**Technical Memorandum**

SUBJECT: Review of Hale (S&K No. 1, LLC) sand/gravel mining permit application

PCD FILE NO. PPR1914
PCD FILE NO. AL1829
ISSUED: 05/07/2019
SITE PLAN
SHEET 2 OF 2

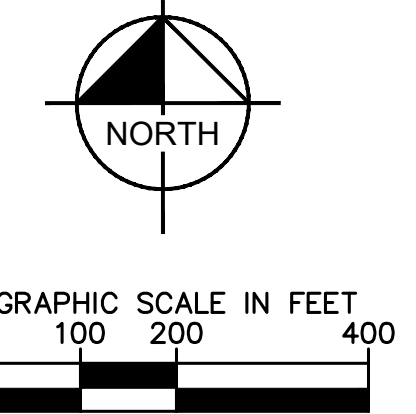
3. There is no information in the mine plan about long term maintenance of the stockpiled topsoil and diversion berm. Measures need to be taken to prevent undue erosion. Will this soil be available for site reclamation?

TEST BORING LOCATION DIAGRAM
HALE ~ SEC. 24, Twp 125, R 63 W

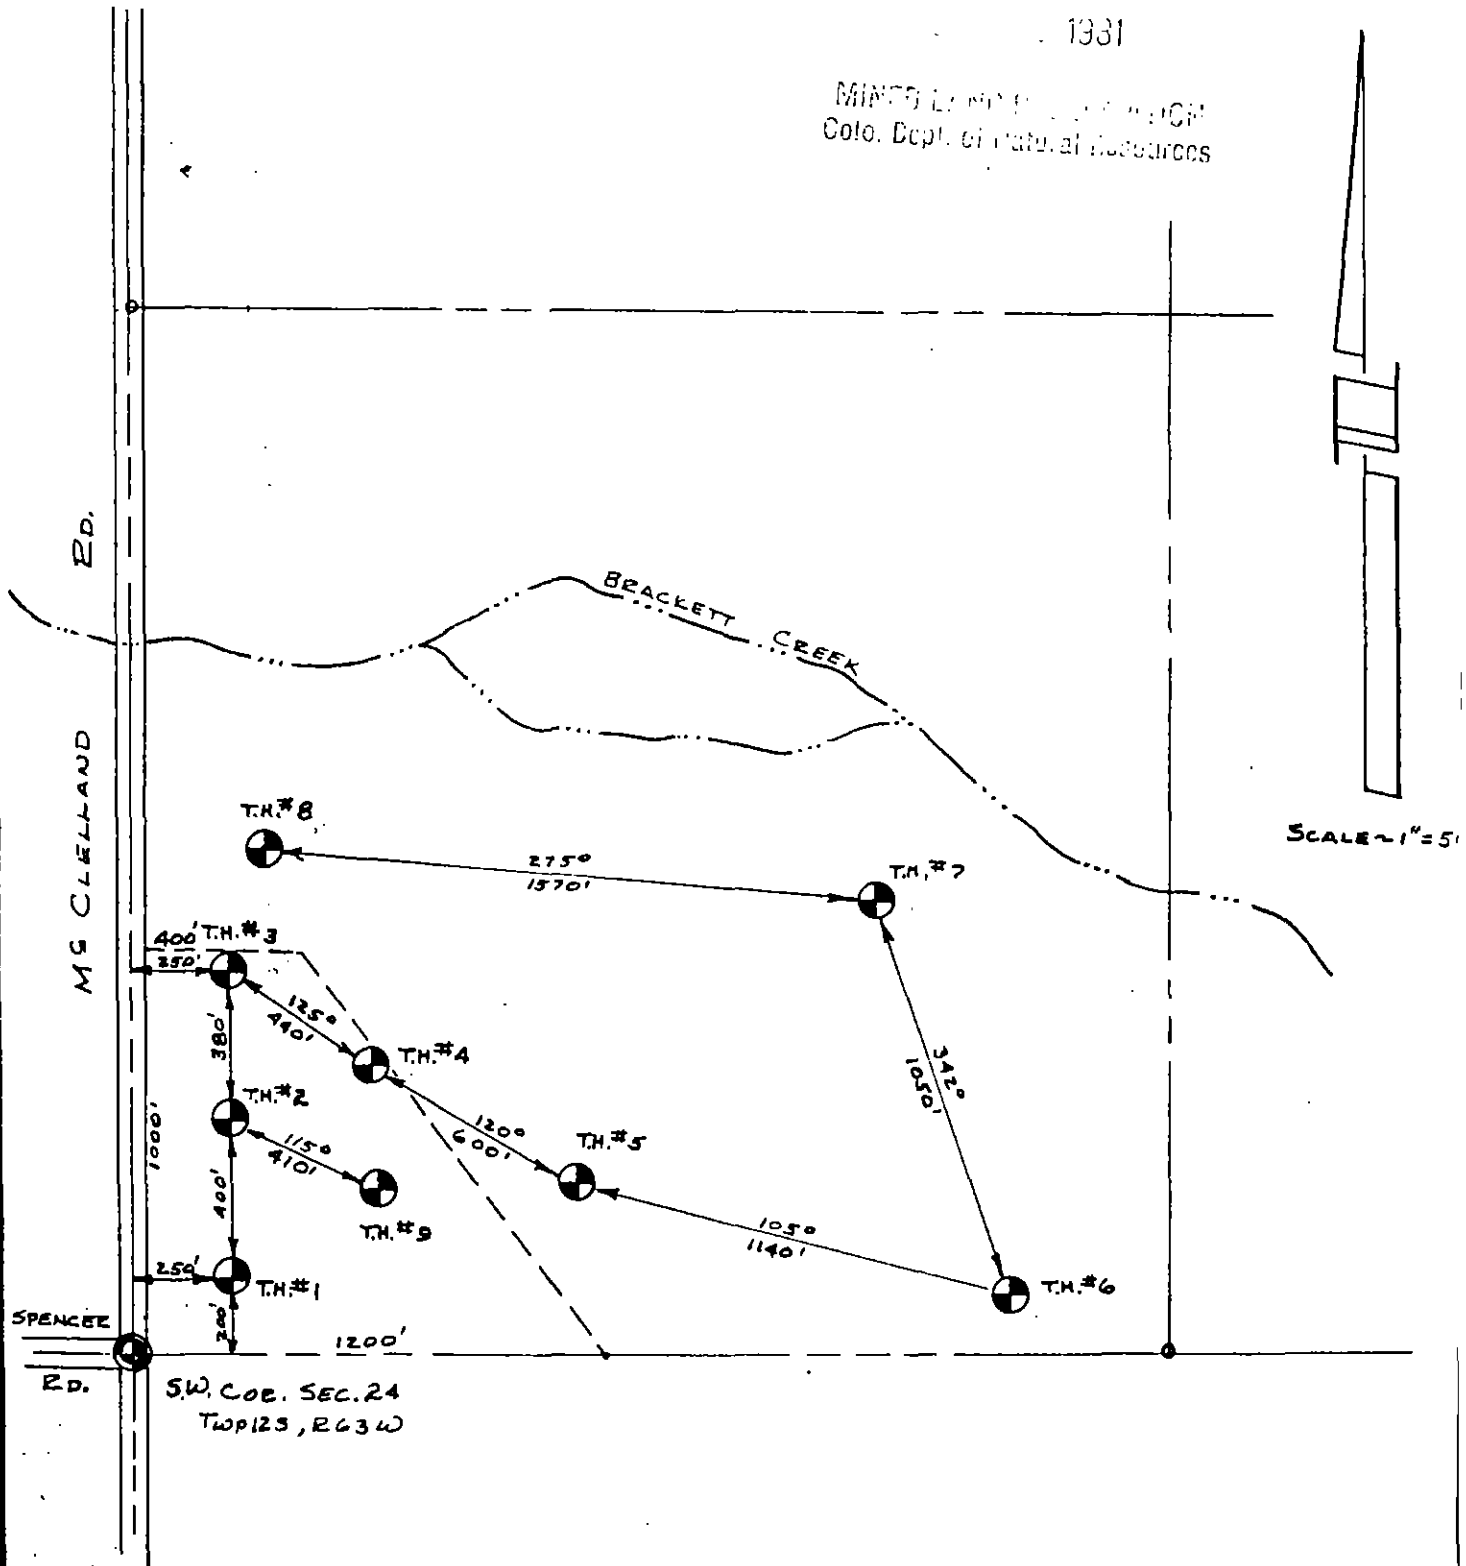
6. The historical documents included part of a report referred to as the Lincoln-Devore report which was apparently prepared to support the 1981 permit to mine. This report discusses a landfill - either existing or proposed - at the Hale site. It is unclear what this refers to. The applicant should provide clarification as to whether there is a landfill and, if so, was it remediated?
